From: Colin Sharpe
Sent: 21 December 2011 15:45
To: planning
Subject: FW: Consultation on planning application 3/2011/0860 Old School Room, Walker Fold, Chaigley

The proposed access arrangements for this development represent a considerable improvement on the existing situation. I therefore have no objection to this proposal, subject to the following conditions:

**Landscaping
schedule**

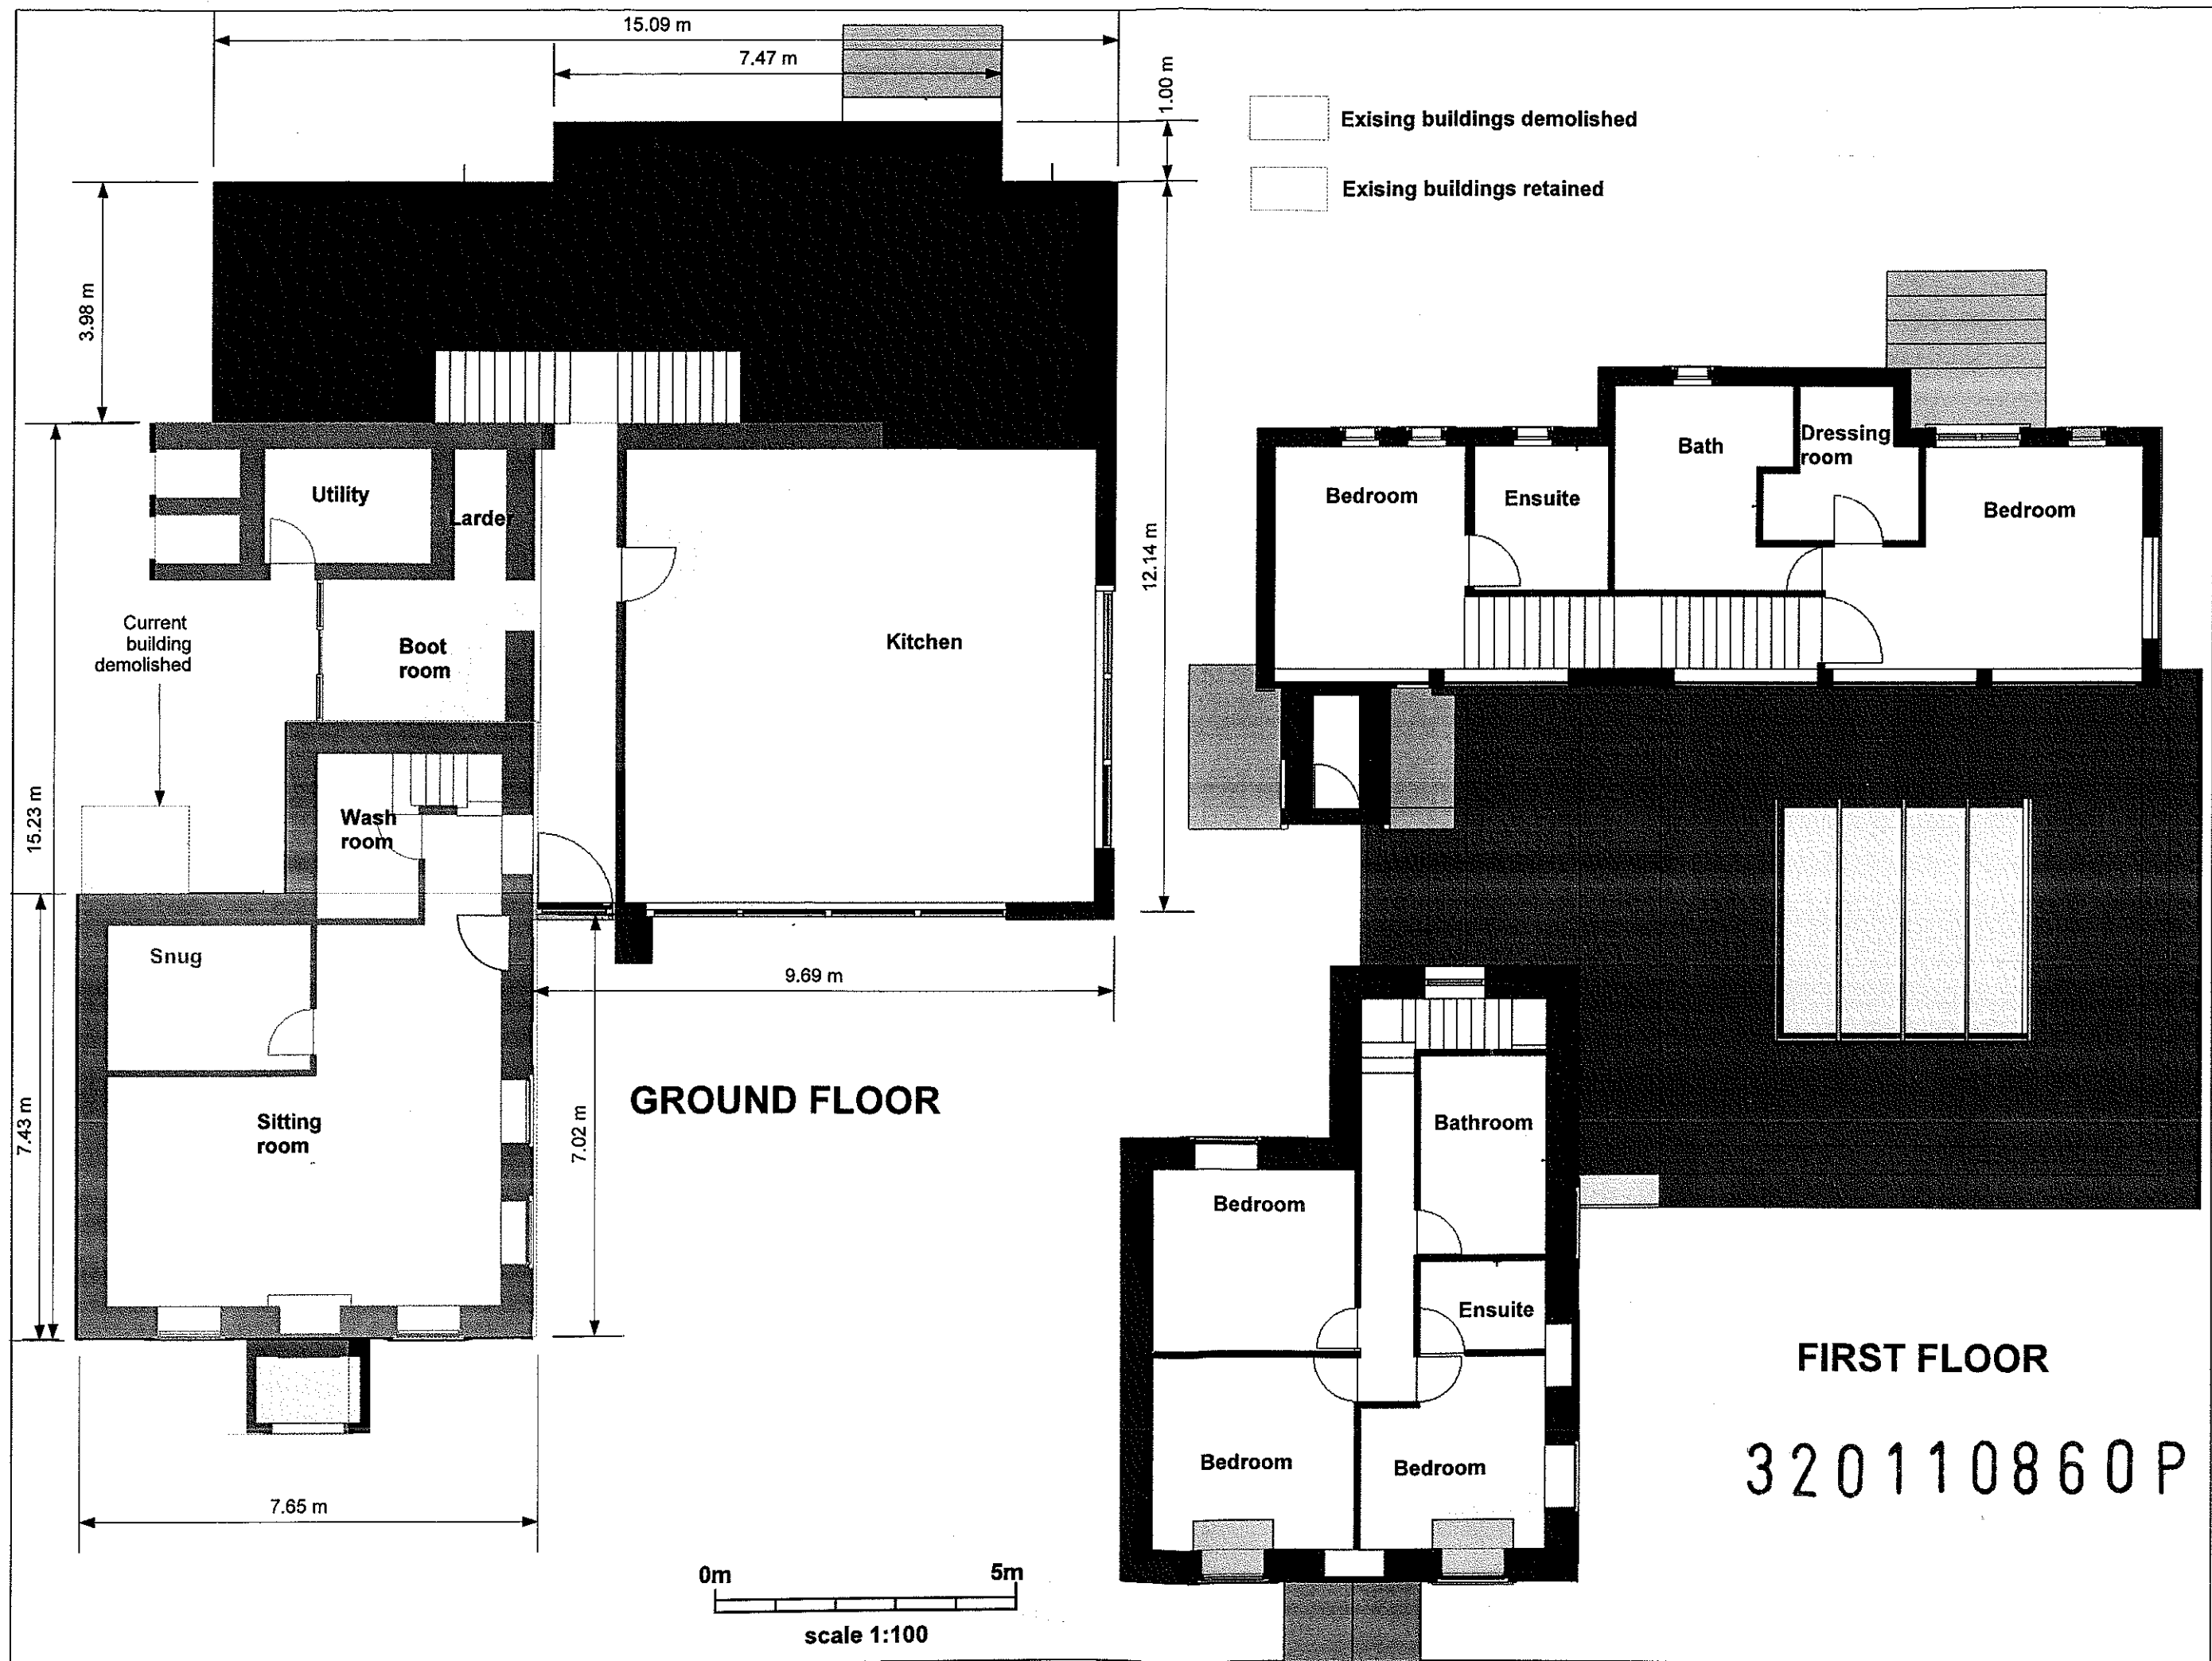
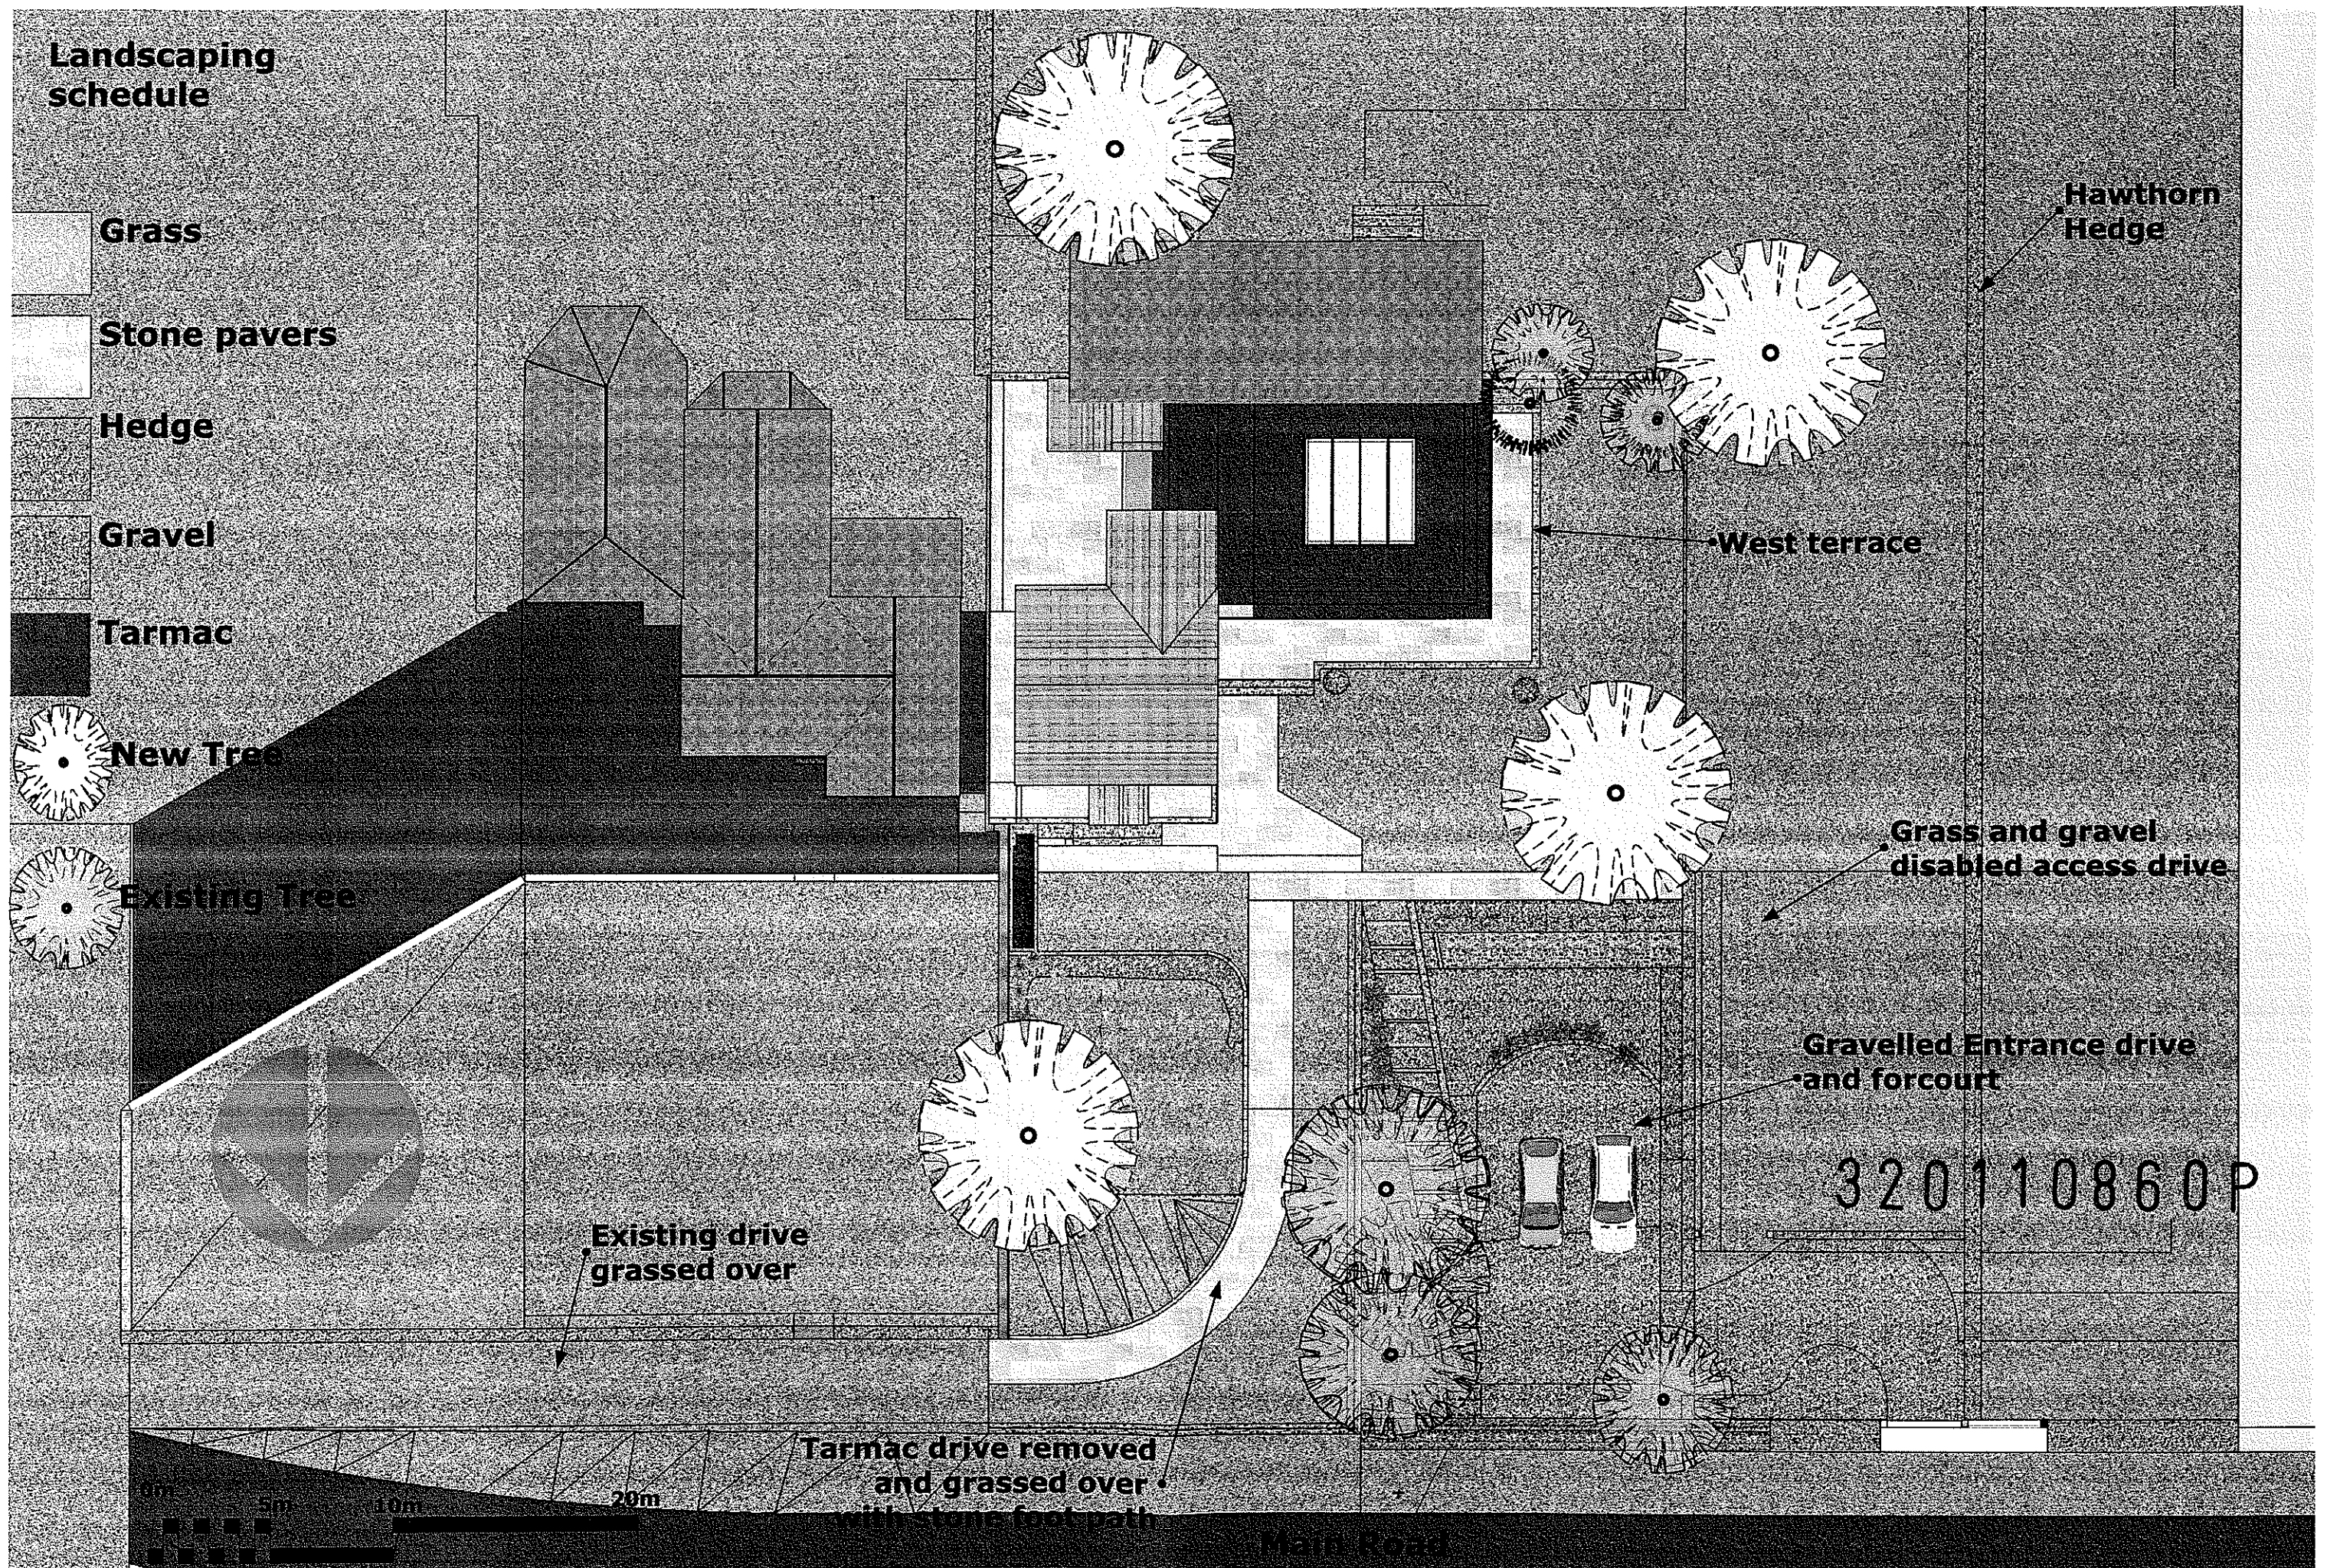
3. The existing access shall be physically and permanently closed and the verge over which the access crosses shall be reinstated. Reason: To limit the number of access points to the highway and in the interests of highway safety.
